SDNP/21/06400/ADJAUT

Proposal: Adjoining Authority Consultation - Approval of details reserved by condition imposed under A/40/18/OUT relating to condition 5-Design Code Master Plan.

Address: Land North of Water Lane Angmering

ADC Reference numbers: A/248/21/PL, A/252/21/DOC, A/256/21/RES

Constraints plan ►

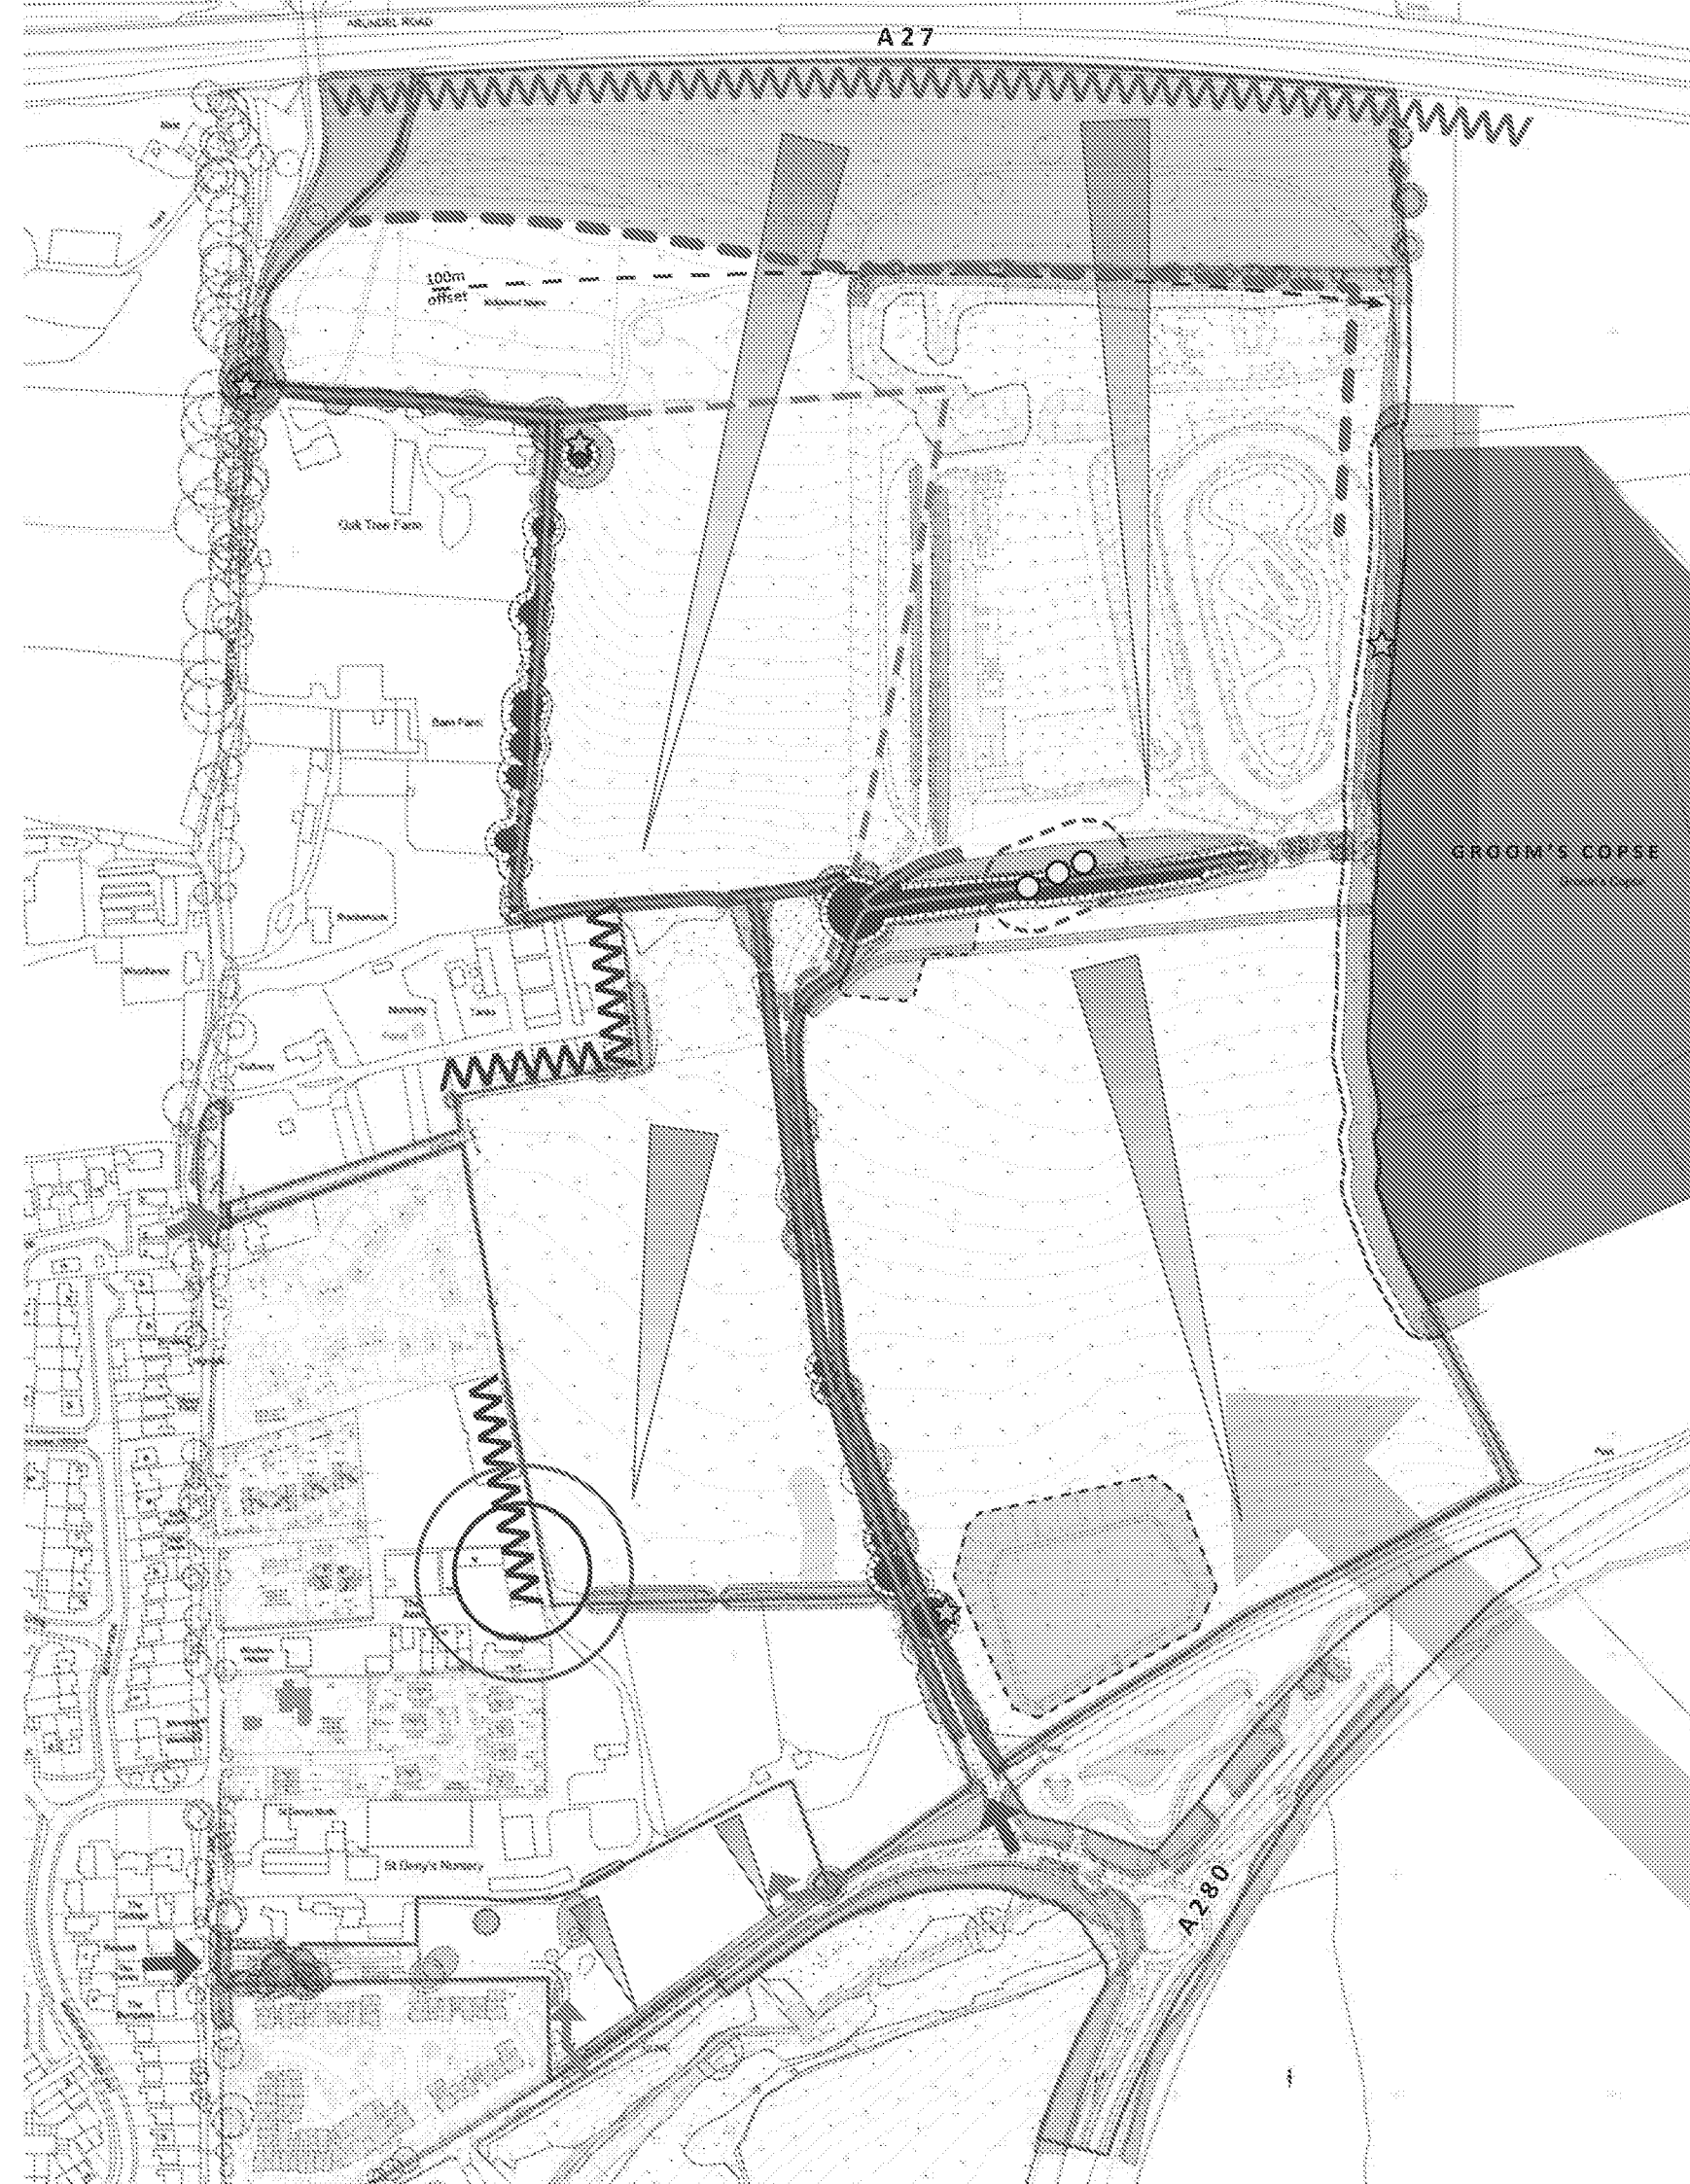
The general principle of stronger green infrastructure, including habitat linkages and increased tree cover within the development is to be welcomed, as is inclusion of a planted buffer from Grooms Copse ancient woodland (although the 15m distance set out in NE standing advice should be seen as an absolute minimum). It is a pity that the thick belt to the north of the existing motor circuit would be lost and the opportunity should be taken to consider thicker planting to the northern boundary alongside the A27. Whilst screening planting is not always the appropriate solution in landscape terms, in this case it could reduce views between the site and the A27, as well as reducing potential desire for an acoustic wall alongside the road in the future. The woodland planting to this and the eastern should be treated in a way that is characteristic to the local landscape and be designed to provide a positive contribution, rather than having a parkland feel.

Revised building heights parameter plan

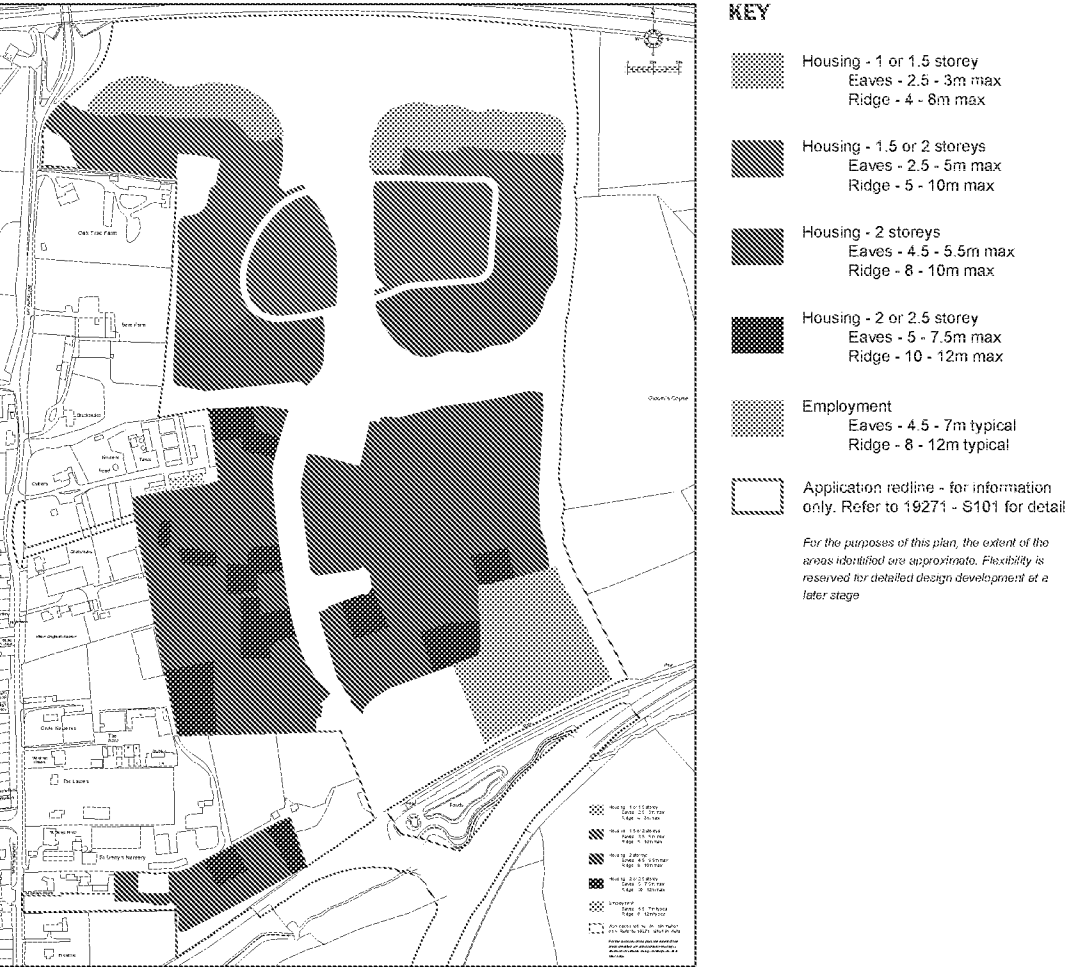
Of greatest significance to the National Park is the extension of the amended layout to the higher ground to the north, into the landscape buffer/public open space. This will affect in particular the views from the SDNP to the south-east, looking across the site and back into the National Park, where this northern field is clearly visible and contributes to the rural character. We note that the overall ridge heights AOD are not intended to change, but this does not necessarily address the noticeable urban expansion further into the northern parts of the site and away from the historic settlement core of Angmering in such views, albeit that the general principle of lower density housing to provide more of a rural edge to the site is welcomed. The SDNPA therefore considers it would be essential for the LPA to secure visualisations in order to properly understand the impacts. These would also help understand the impacts of some of the larger, more bulky (approaching 3 storey) flats to the southern end of the site, as well as the effectiveness of proposed tree planting throughout the site.

Pedestrian & cyclist movement network diagram

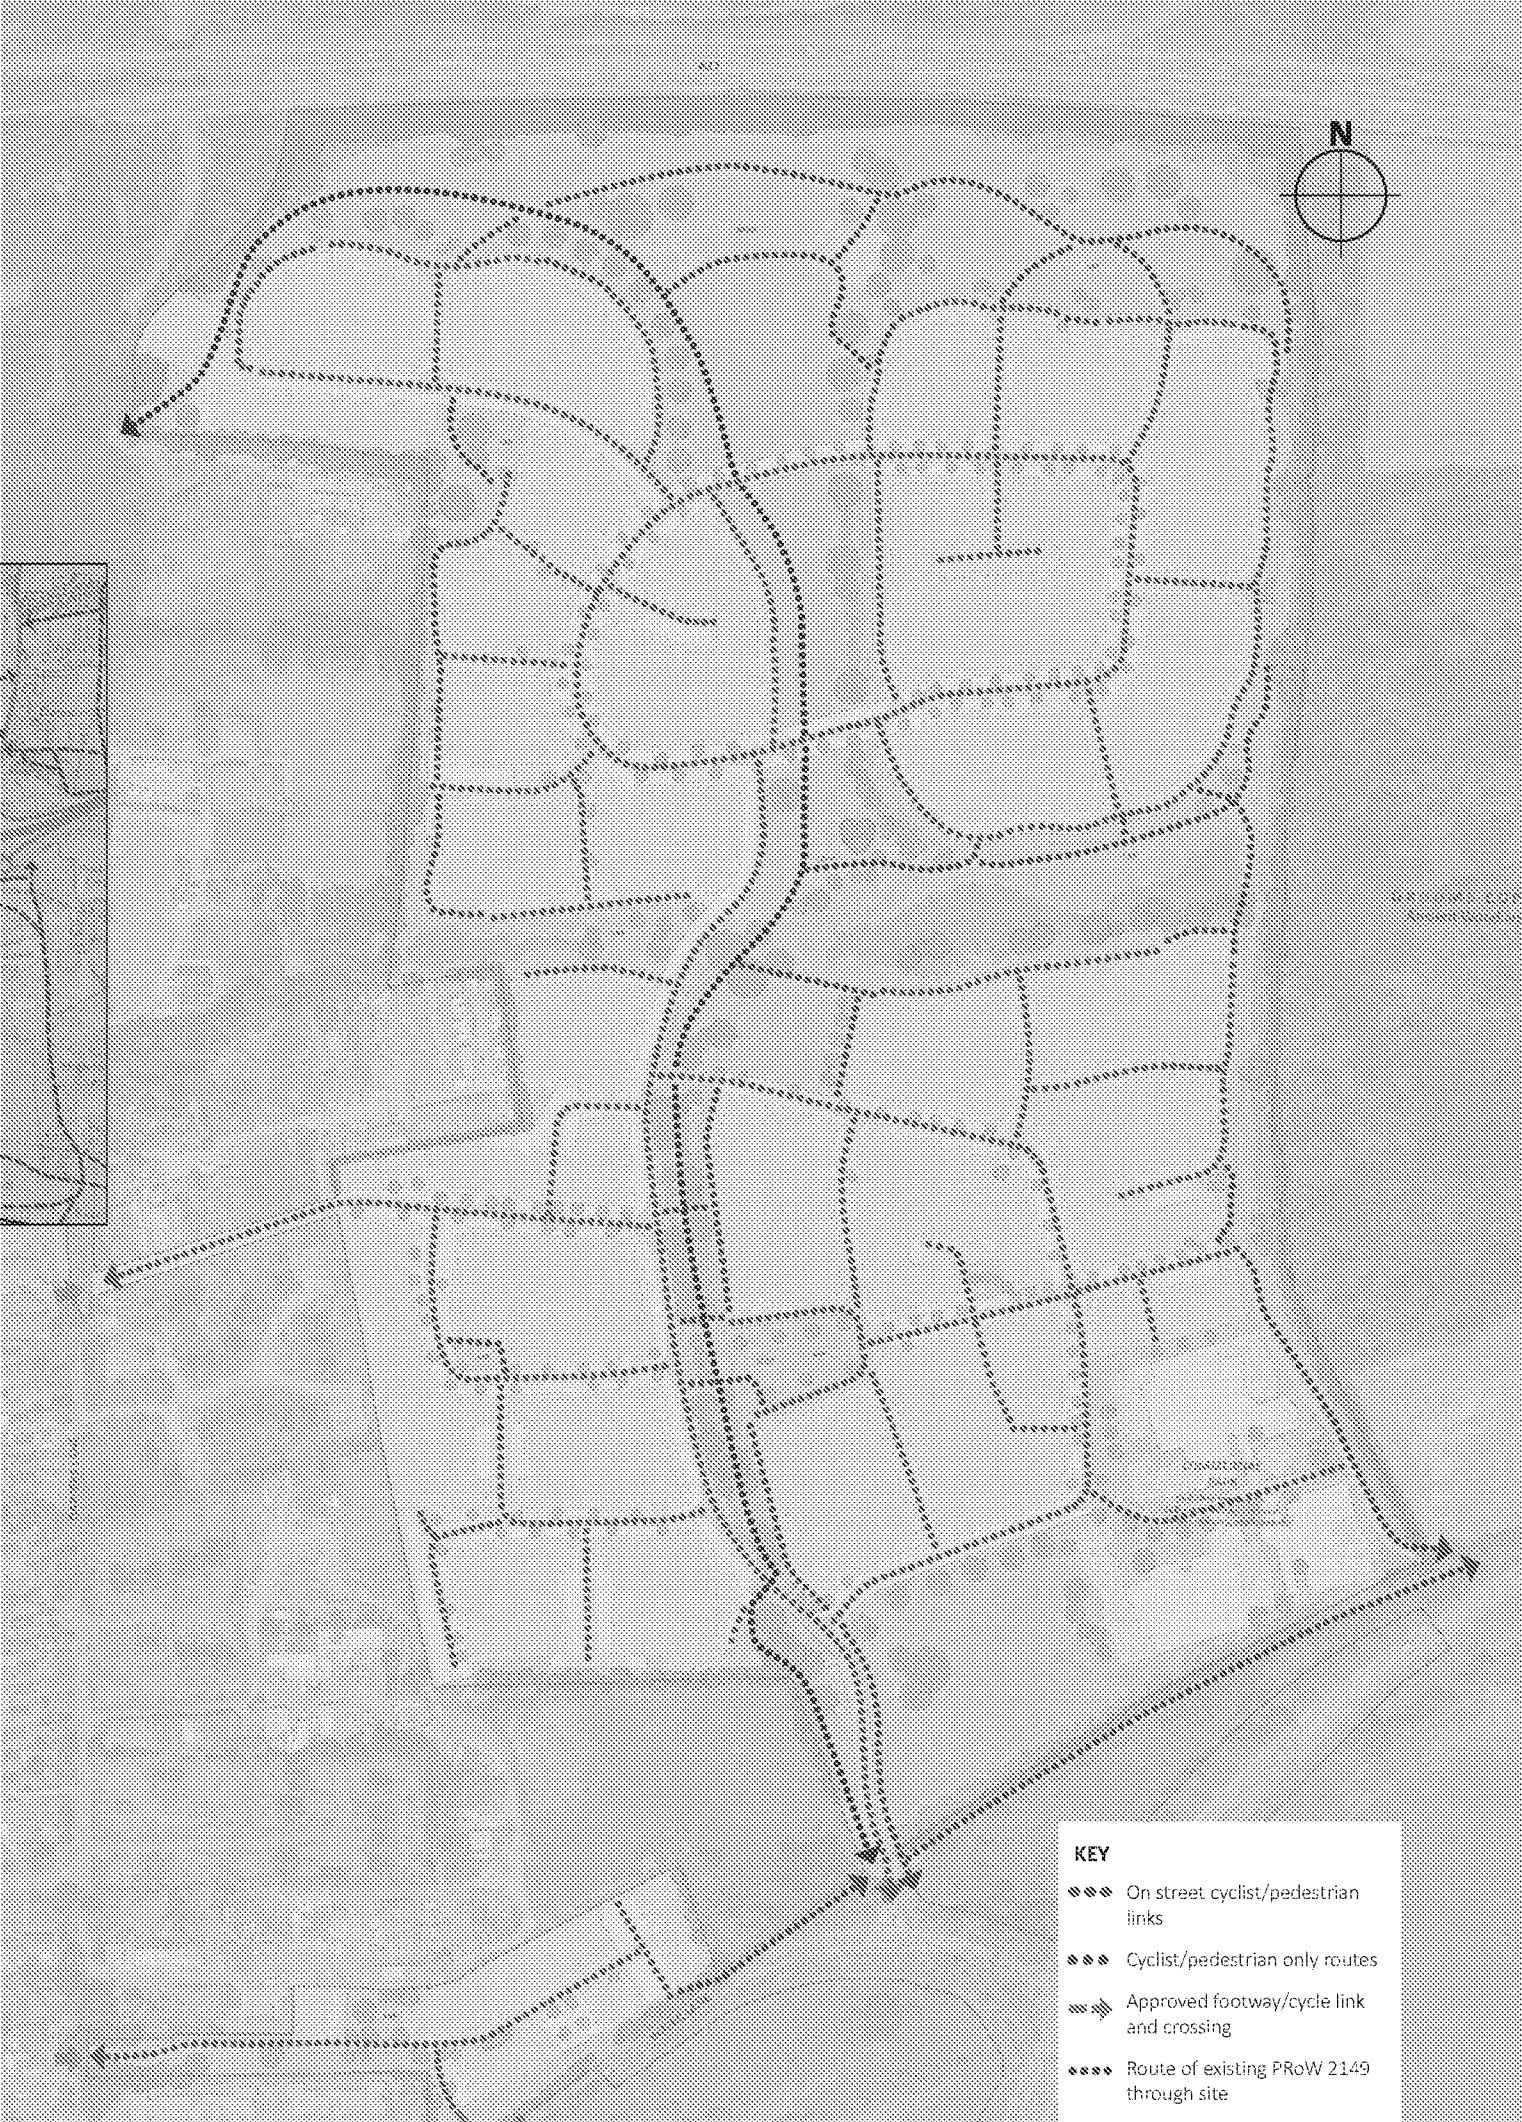
It is noted that the existing footpath through site will be upgraded to a 3m-wide footpath and cycle track, largely off-road. This footpath links onto Dappers Lane which provides the best opportunity for access to the National Park for recreation by means other than the car and. In line with our comments on other development in the area, we would welcome considerations to make Dappers Lane more suitable for such users and we understand that some such improvements are included within a legal agreement. We also note that the proposed access from the main part of the site to Dappers Lane will remain limited to bus and emergency vehicles, and we trust that the LPA is satisfied that this can be suitably controlled.
